The Secretary
NSW Department of Planning, Industry & Environment

15 July 2022

I refer to the Department's email of 12 July 2022 regarding the exhibition of the Environmental Impact Statement (EIS), for State Significant Development SSD-11606719 Eastern Creek Recycling Ecology Park Throughput Increase for 'Environmental Impact Statement (EIS) for Eastern Creek Recycling Ecology Park Throughput Increase. Increase in throughput of an existing Recycling Ecology Park from 2 million tonnes of waste per annum (tpa) to 2.95 million tpa, including upgrade of supporting site infrastructure' at 1 Kangaroo Avenue, Eastern Creek (Lots 1-2 DP 1145808, Lot 2 DP 1247691, Lot 7 DP 1200048) in the Blacktown City Council Local Government Area (LGA). Submissions need to be made to the Department by 10 August 2022.

PRELIMINARY

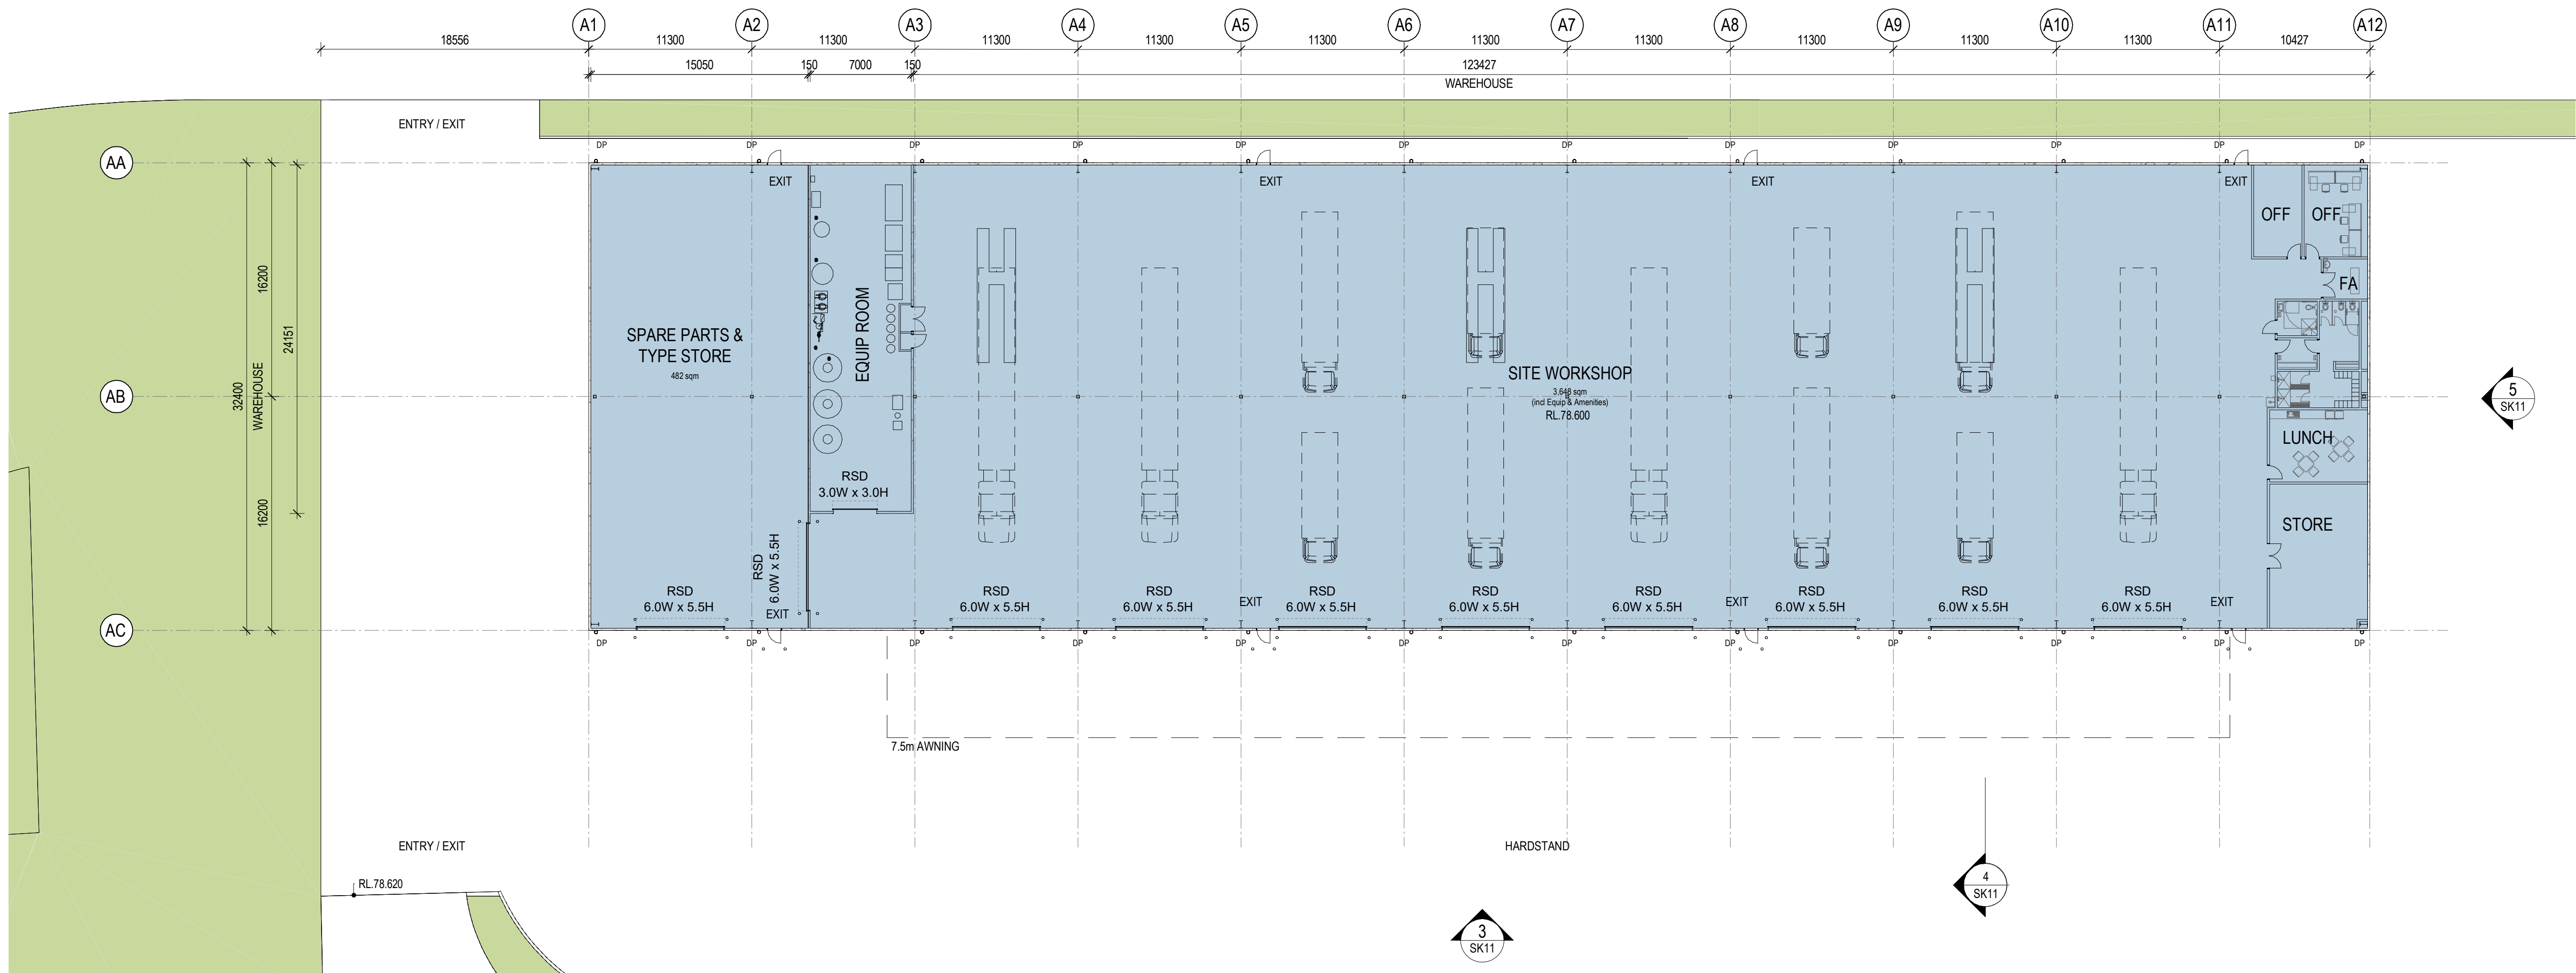
The electrical substations do not appear to be shown in the Architectural Drawings or the Project Visualisations. Any required padmount substation/s will need to be located within the property (in a suitable and accessible location) and be protected (including any associated cabling) by an easement and associated restrictions benefiting and gifted to Endeavour Energy. Please refer to Endeavour Energy's Mains Design Instruction MDI 0044 'Easements and Property Tenure Rights'.

Generally it is the Level 3 Accredited Service Provider's (ASP) responsibility (engaged by the developer) to make sure substation location and design complies with Endeavour Energy's standards the suitability of access, safety clearances, fire ratings, flooding etc.
